Recommendation Report for Planning Permission for Works or Extension to a Dwelling

REF NO: LU/119/21/HH

LOCATION: 48 Pier Road  
Littlehampton  
BN17 5LP

PROPOSAL: Conversion of roofspace to habitable use to include a rear dormer, Juliet balcony, front dormer with terrace and conversion of roof from hip to gable end.

DRAWING PLANNING	SCALE 1/100
DATE: APRIL 2021	
DRAWN: T. Murray	
DRAWING: 21/28/1	REVISION:

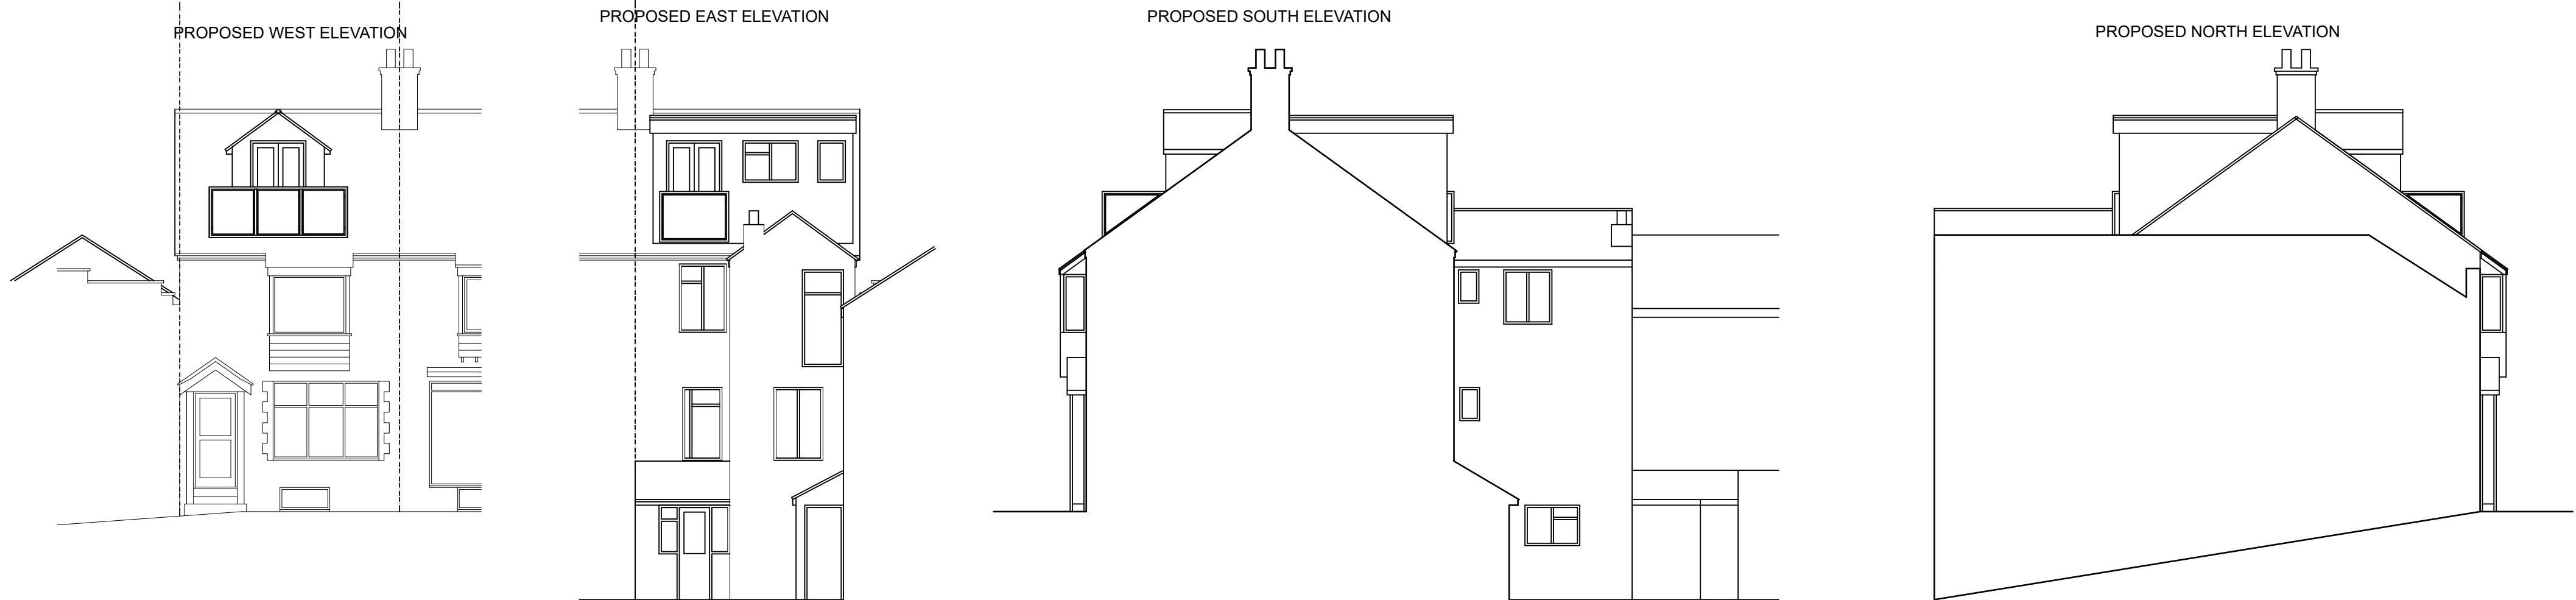
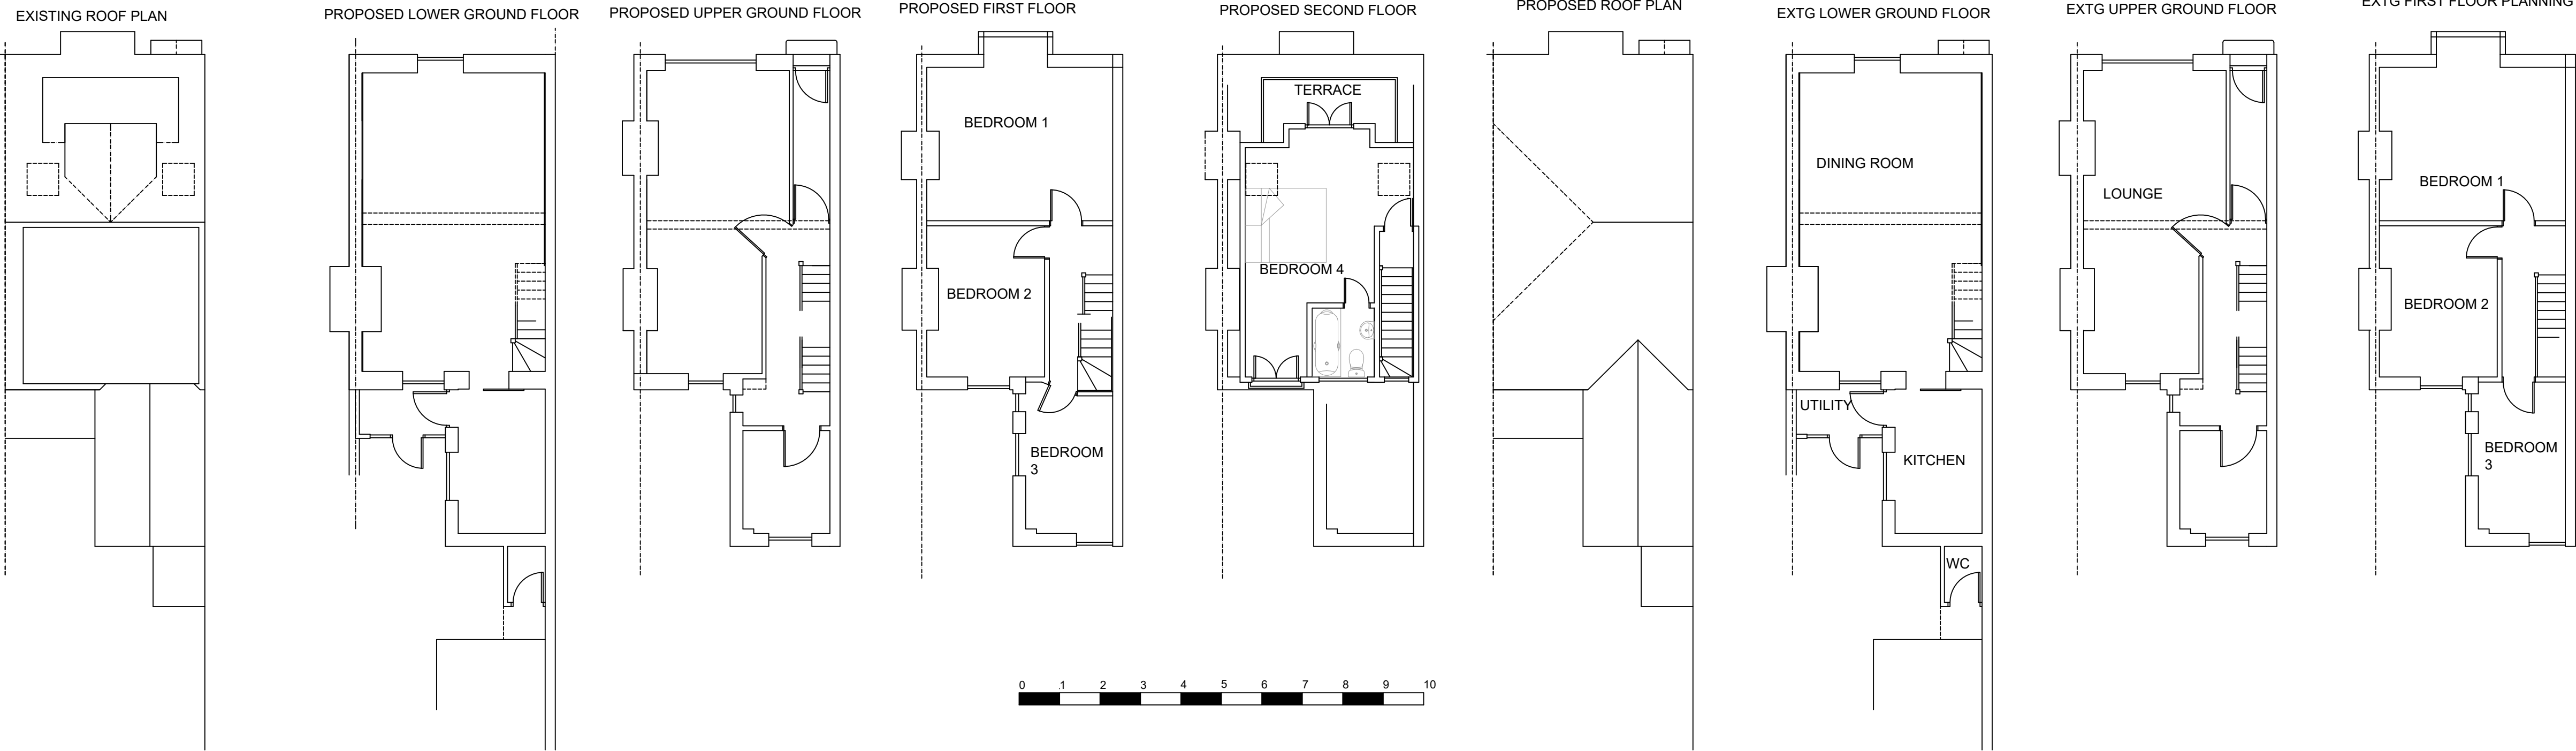
This application proposes a hip to gable extension with front and rear dormer. The scale of the development in terms of design and size conflicts with Aruns Design guide part M which favours small scale roof extensions. It is noted there are properties in the near vicinity with front dormer and rear dormers No 55 and No 58. In regard to the hip to gable extension, due to lack of uniformity in the parade in terms of roof profiles designs well as variation in height it is difficult to justify the refusal, as no harm to the visual amenity is demonstrated. There is also PD fall back position for rear dormer and hip to gable extension.

A roof terrace has been proposed to the front which will afford direct views of the river front walkway and no overlooking into the adjoining properties. A rear dormer with openings would only have limited into adjoining dwellings and no greater adverse impact on overlooking than existing first floor windows. The development is not considered to harm neighbouring amenity by way of overbearing, overshadowing or overlooking and accord with D DM1 and D DM4 of the Arun Local Plan.
